Report of the Head of Development Management and Building Control

Address: 84 TOLCARNE DRIVE PINNER

Development: Proposed change of use from a Residential dwelling (Class C3) to a 6-persons max small HMO (Class C4) (Application for a Certificate of Lawful Development for a Proposed Development)

LBH Ref Nos: 35338/APP/2024/1664

Figure 3: Ground floor alterations to facilitate change of use.

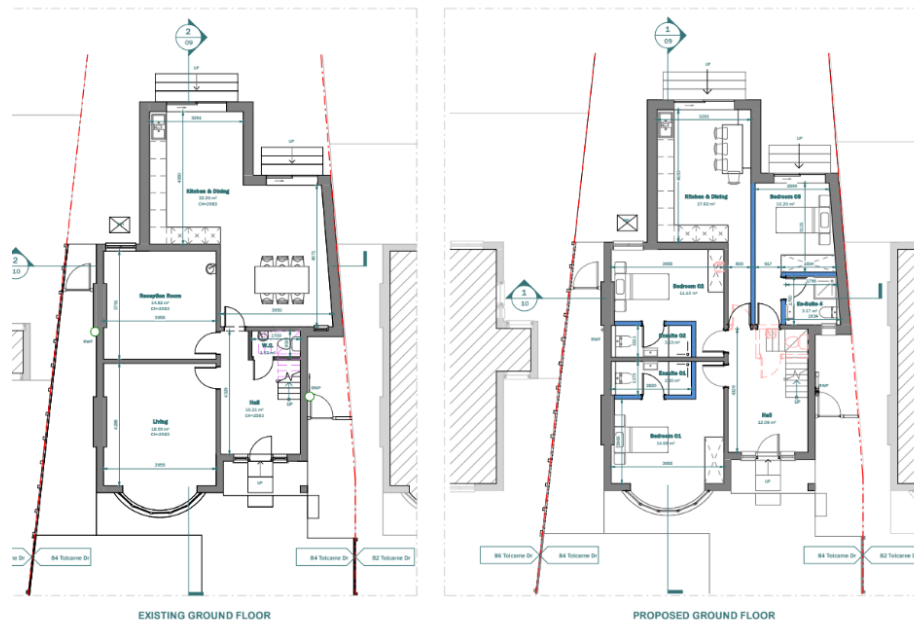
- Bedroom 1 - 14.68 sqm + en-suite (3.3 sq m)
- Bedroom 2 - 11.10 sqm + en suite (3.13 sq m)
- Bedroom 3 - 10.20 sqm + en suite (3.17 sq m)
- Bedroom 4 - 12.66 sqm + en suite (3.07 sq m)
- Bedroom 5 - 10.14 sqm + en suite (3.02 sqm)
- Bedroom 6- 10.20 sqm + en suite (2.03 sqm)
- Hallway: 12.08 sqm
- Shared Kitchen / Dining Area: 17.62 sqm

Given the internal floorspace of the bedrooms, it is considered that bedrooms 1 and 4 would both be capable of use by up to two occupants, according to the internal space standards as set out within the London Plan (2021). Given the presence of four single bedrooms and two double bedrooms, it is considered that the HMO would be capable of use by up to 8 occupants, contrary to the stated maximum of 6 occupants stated within the application. This would be considered to breach the permitted development threshold. The additional information submitted in respect of tenancy agreements does not change this consideration.

It is concluded that within this current application, due to the size of the bedrooms within the property, the dwelling could be occupied by at least 8 occupants and therefore would not be considered as a small scale HMO (Class C4), rather it would be considered a large scale HMO (Sui Generis) use that would require the submission of a full planning application. Through a full planning application it would also be possible to add a relevant condition which would limit the number of occupants of the proposed HMO to 6 persons, which is not possible through a Certificate of Lawful Development.
